After reading the both the Applicants' Responses to the Written Representations, and the Examiner's Second written questions, I wish to make the following points.

7.5 Habitat Constraints Plan

Figure 6.10.1: Great Crested Newt (GCN) Survey North

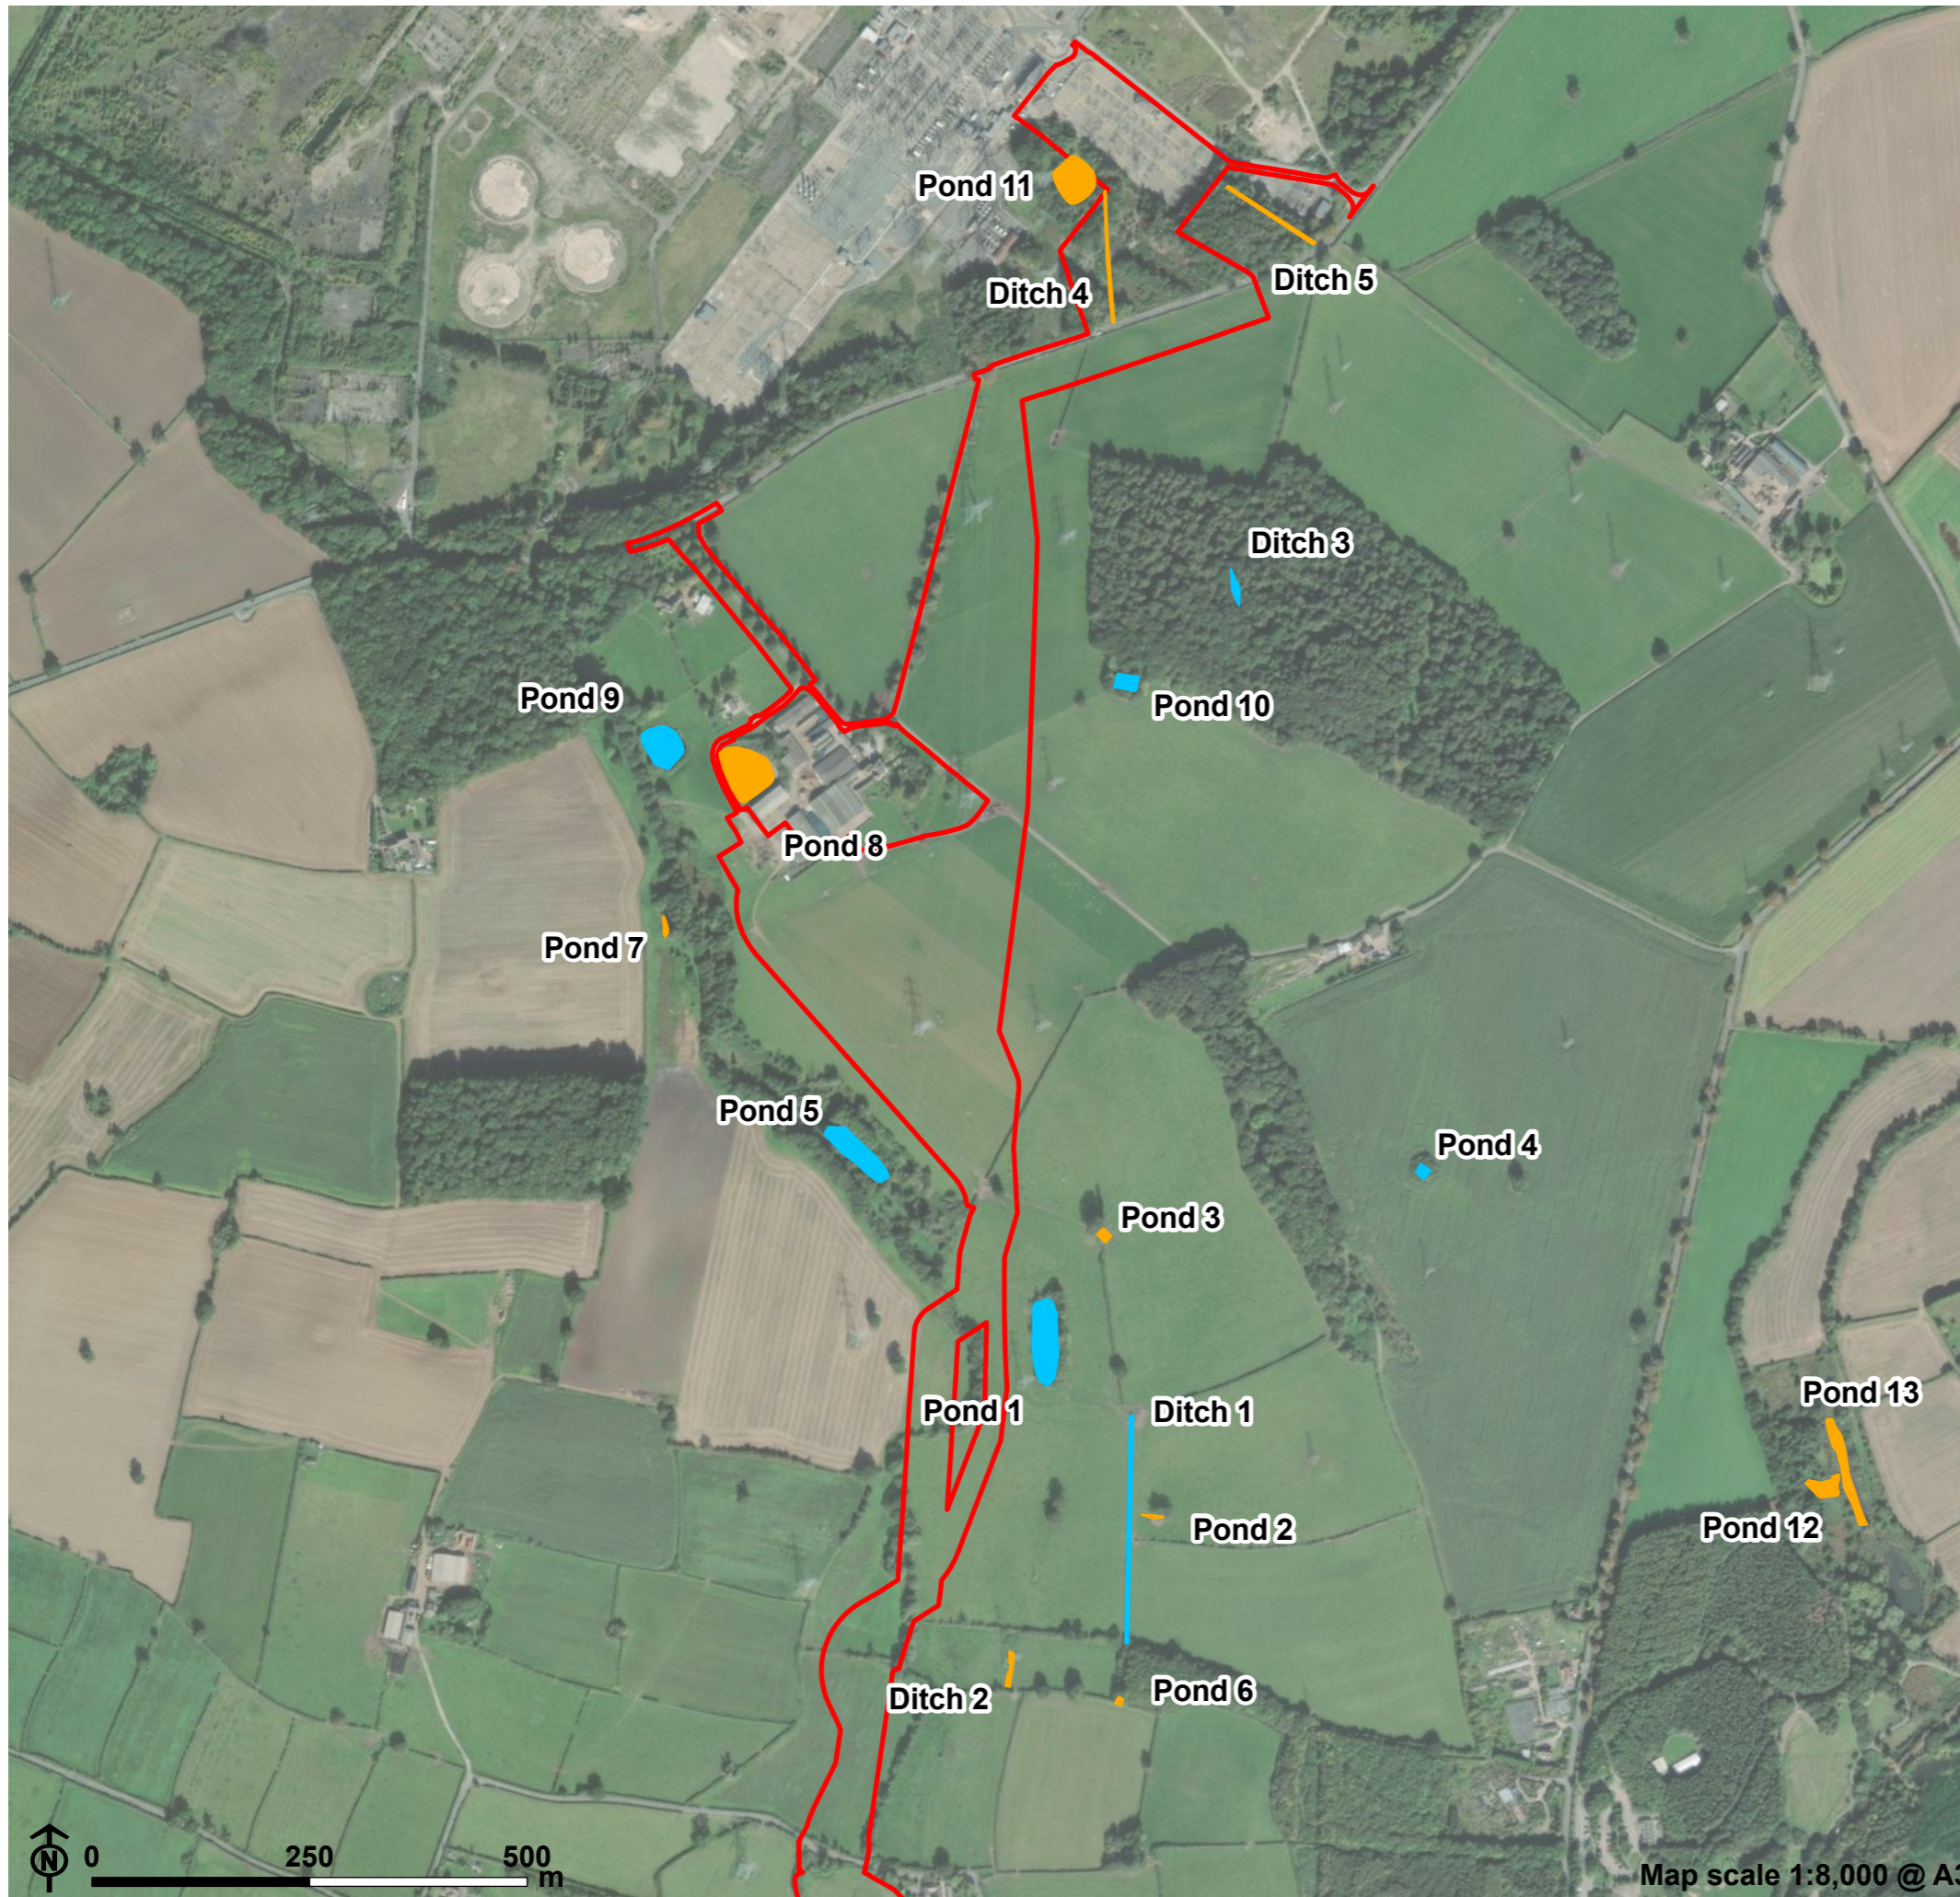
GCNs are known to be able to travel distances of up to 1km when colonising new habitats, but when siting new ponds (to increase GCN habitat) the typical guidance is to ensure they are within 250m of each other for easy access. The Applicant's proposed limit of surveying only ponds within 100m of the site therefore seems unduly restrictive.

**Figure 4-3 Depth of flooding in a 1% surface water flood event**

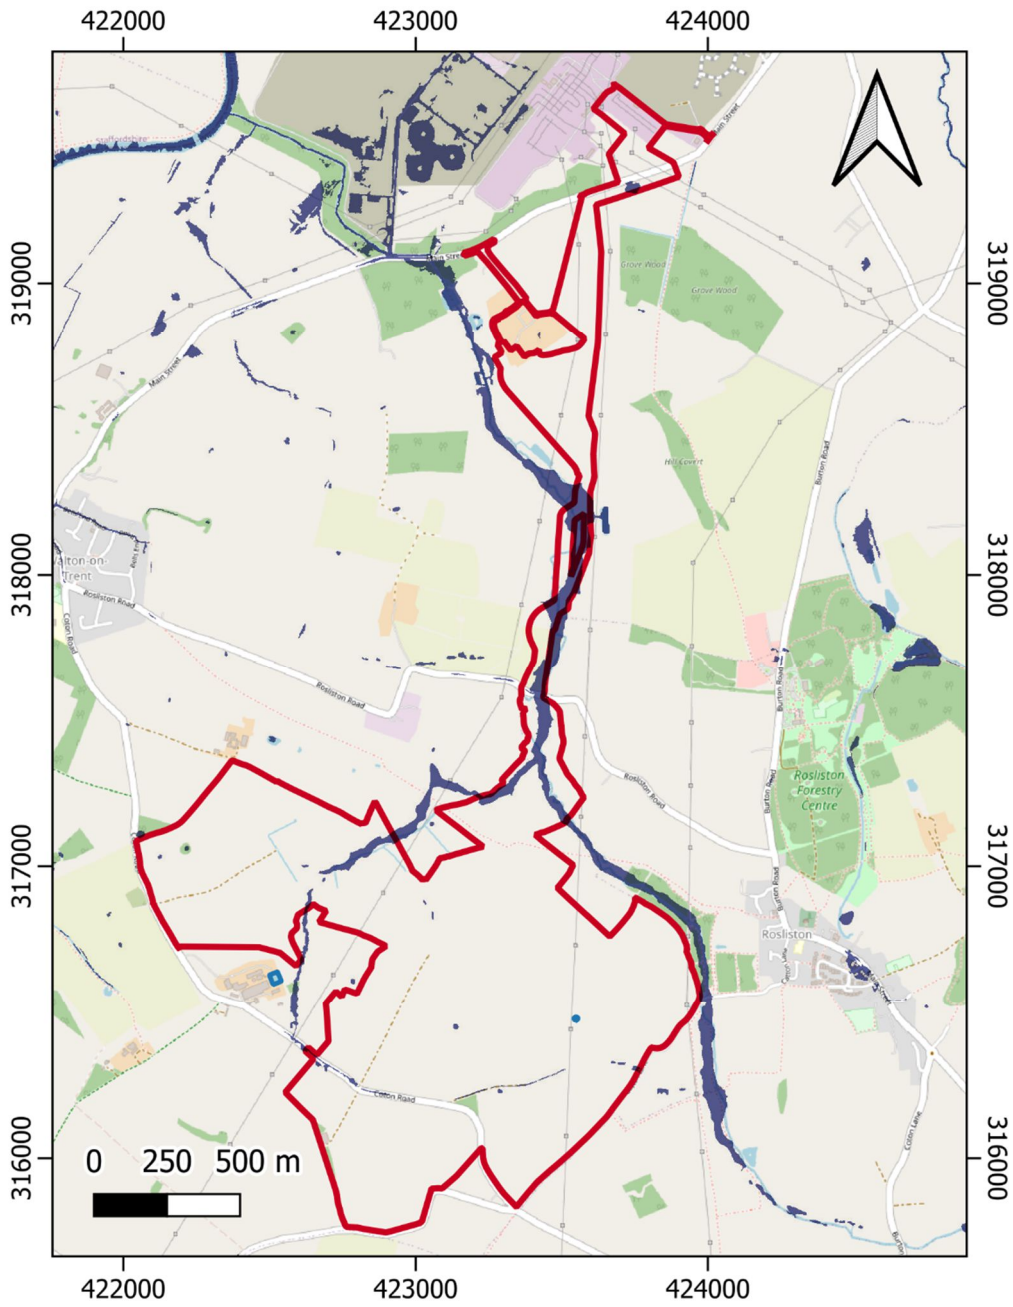
The statement in Chapter 8 that "Flood depths... are expected not to exceed 300 mm however, and they should remain passable with care" is completely contrary to road safety advice. The risk of increased run-off through climate change and possible lower infiltration rates due to the solar infrastructure and on-site access network requires planned mitigation such as SUDs strategically sited to protect the local road network from surface water flooding.

Figure 4.11: Indicative Access Track  
Cross Sections (4.5m/6m/3.5m)

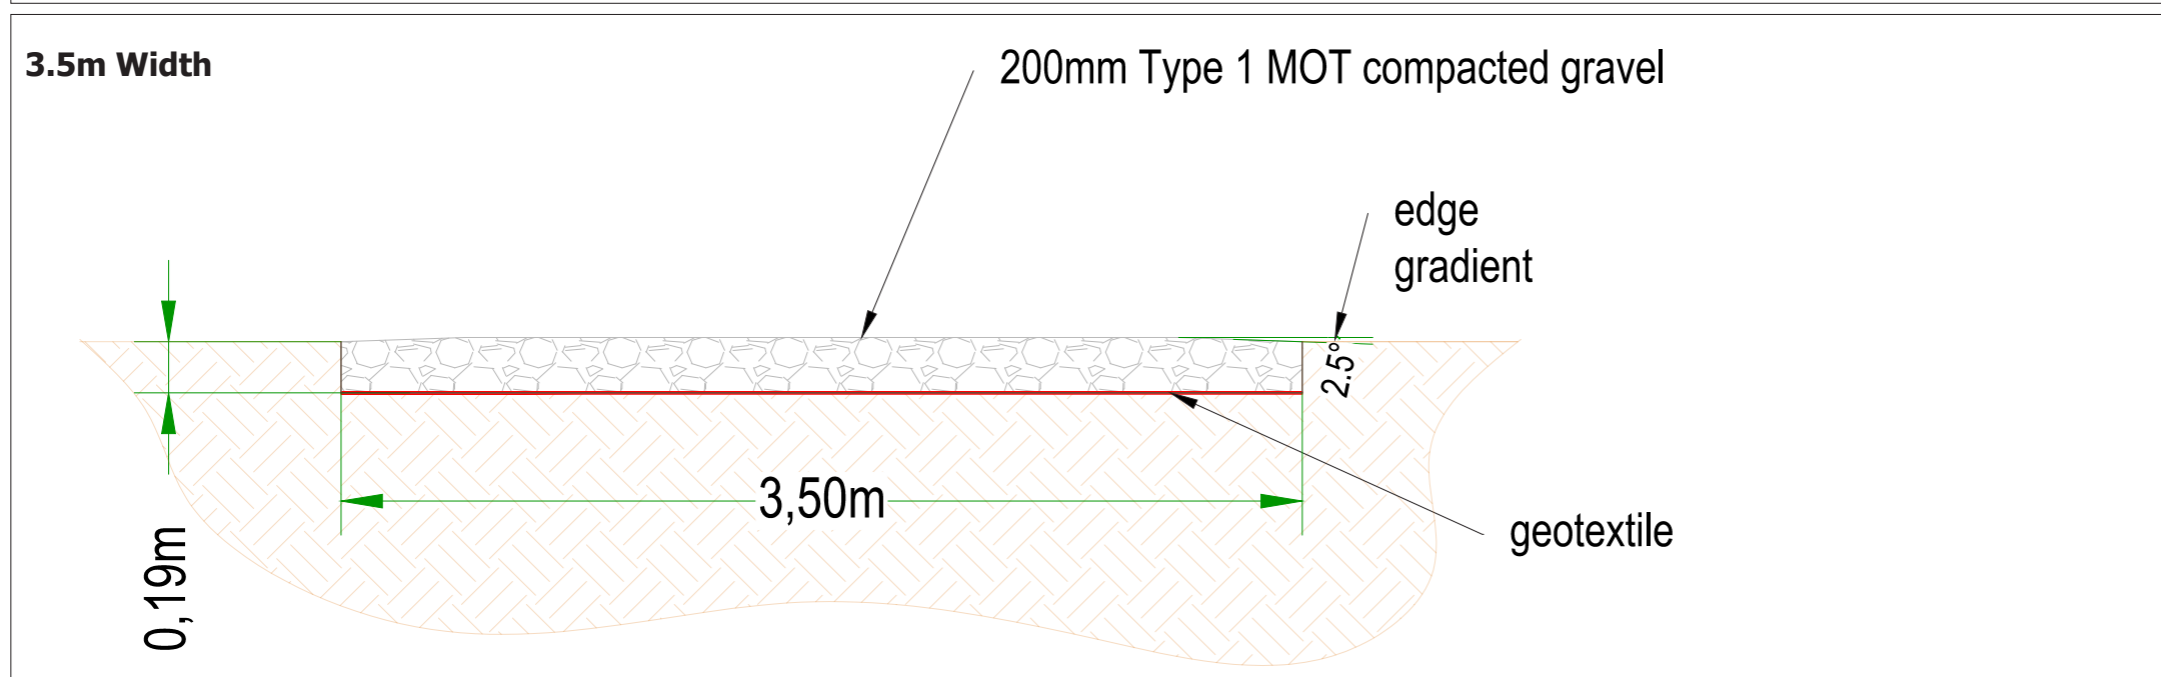
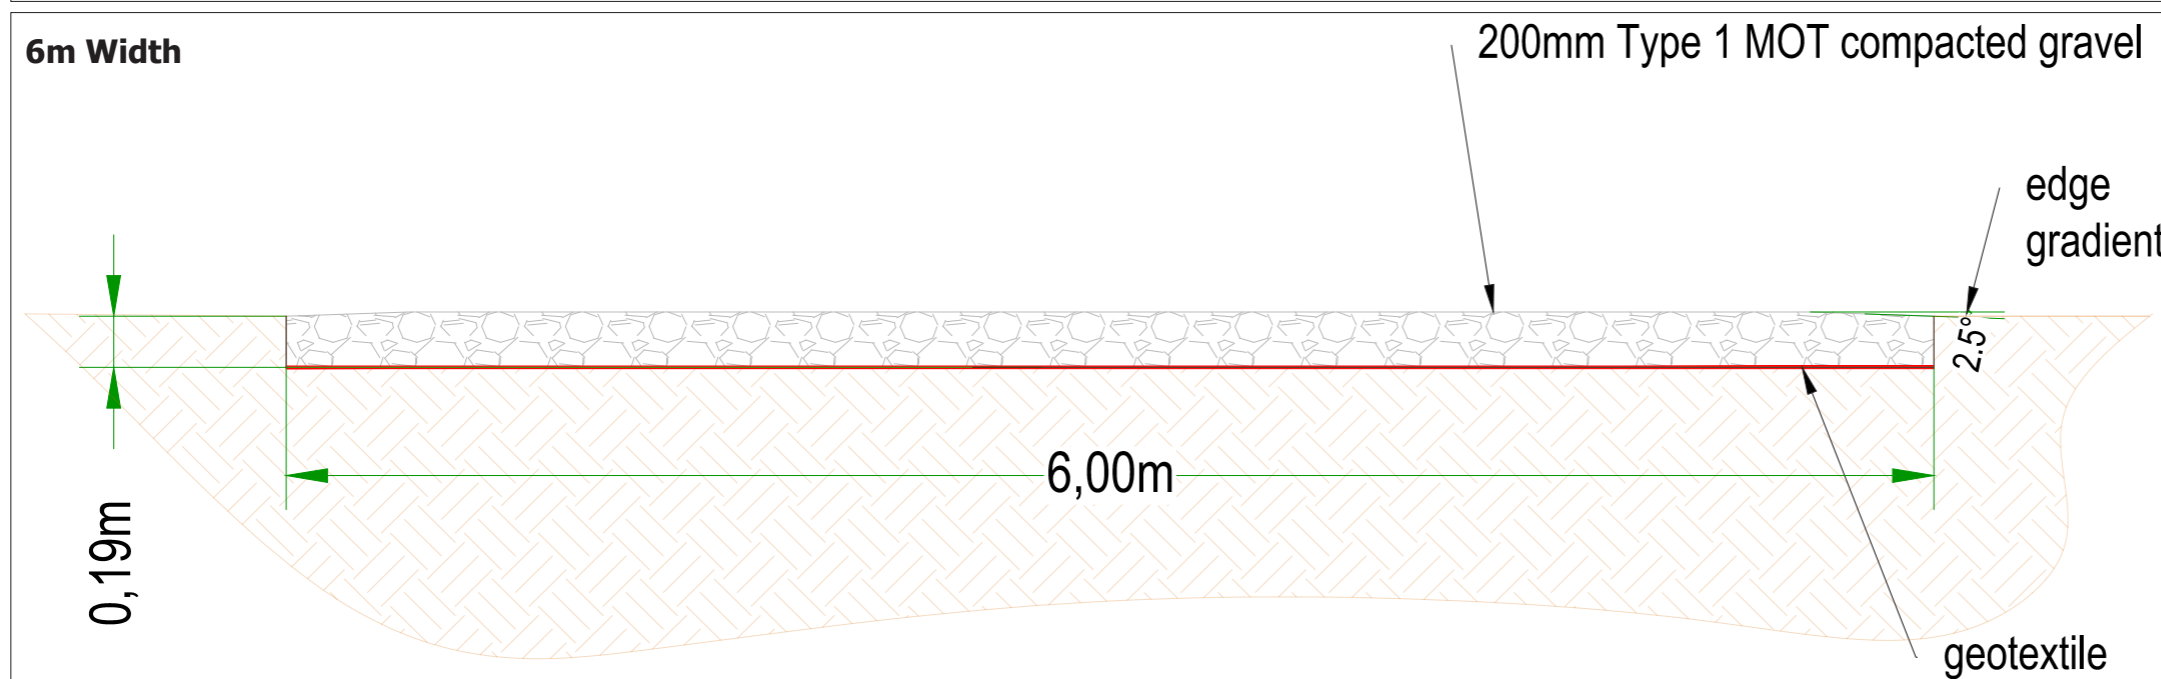
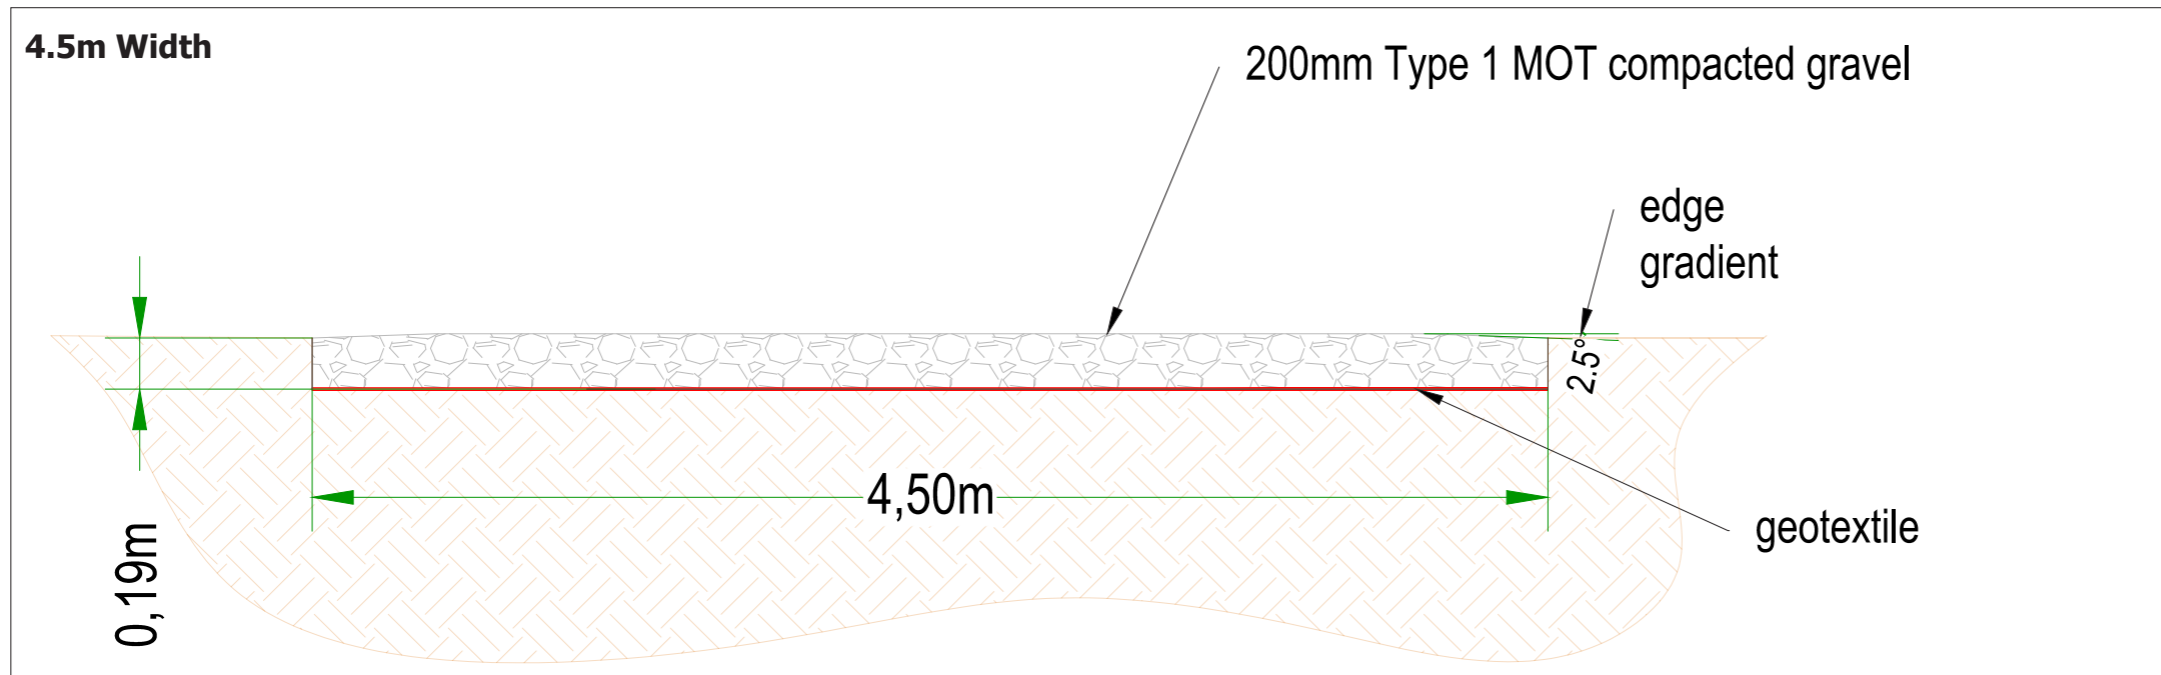
In my written representation, I identified the risk that the construction compound south of Coton Road would potentially impact the well-known landmark of the Twin Oak (T105). The Applicant's response is that protection will be provided in accordance with relevant guidance. Based on BS5837 the tree protection zone will be 15 x stem diameter (approximately 15m diameter) and yet the proposed construction route to the compound will pass less than 5m from the tree.

The Applicant plans a hedge protection zone of 5m for existing hedges. But for new hedges it specifies an offset from the security fencing by 2m. How does the Applicant propose to maintain these hedges if they are this close to the security fence as there is insufficient room for a tractor to drive in between the gap.
